Our Case Number: ACP-324568-26

Re: Proposed Development of the Barnesmore Gap Greenway Project
County Donegal

Re; Barnesmore Gap Greenway Project, Donegal Co. Council, (Plot Number 1029)

We wish to make the following observation with regards to Chapter 16, Volume 2, of the Environmental Impact Assessment Report, which has been included as part of the current planning submission prepared by Donegal Co. Council in respect of the above proposal.

Figure 4-21 - Farm Crossing Gate Detail (Open for Greenway Users)

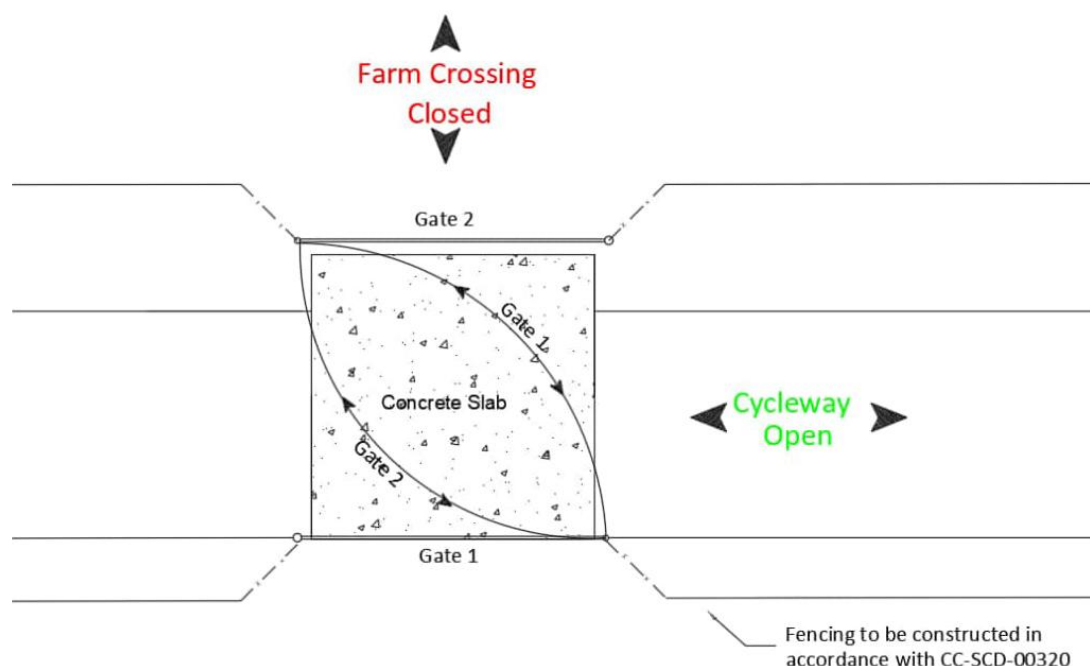
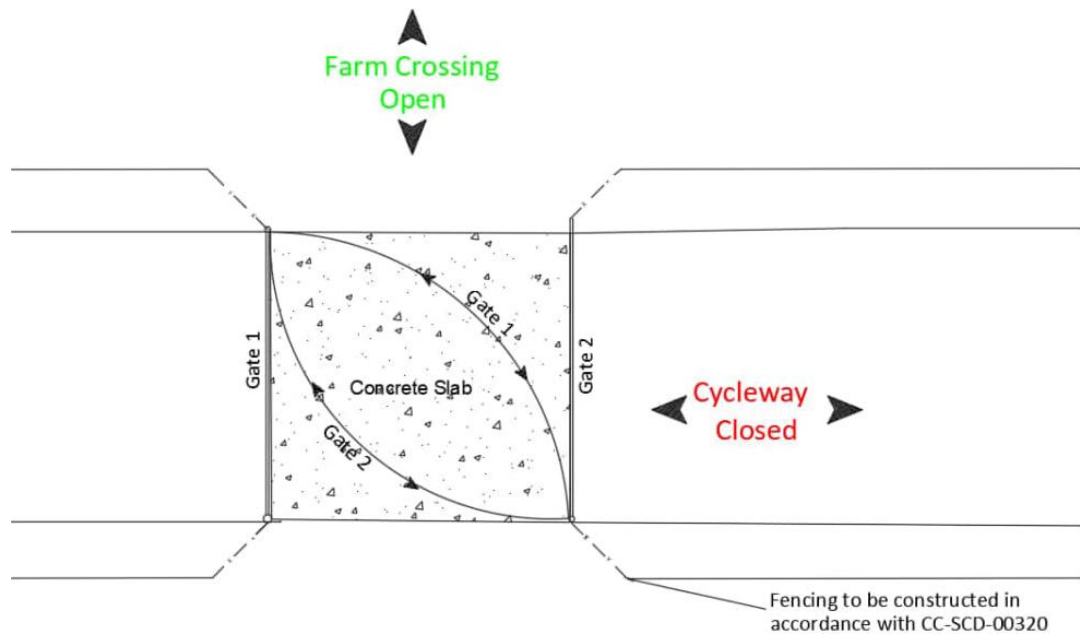
There will also be restrictions on access to the farm and use of existing farmyard facilities etc. The proposed provision of crossing gates across the greenway to facilitate access between the two sides of the farm is appreciated and obviously necessary, but will also introduce additional operational requirements and restrictions that do not currently exist.

The combination of the physical division of the farm, the loss of access to the existing water supply for one half of the holding, the restrictions on access to the farmyard and retained lands, and the requirement to use crossing gates will result in considerable and significant changes to the day-to-day management and operation of the farm.
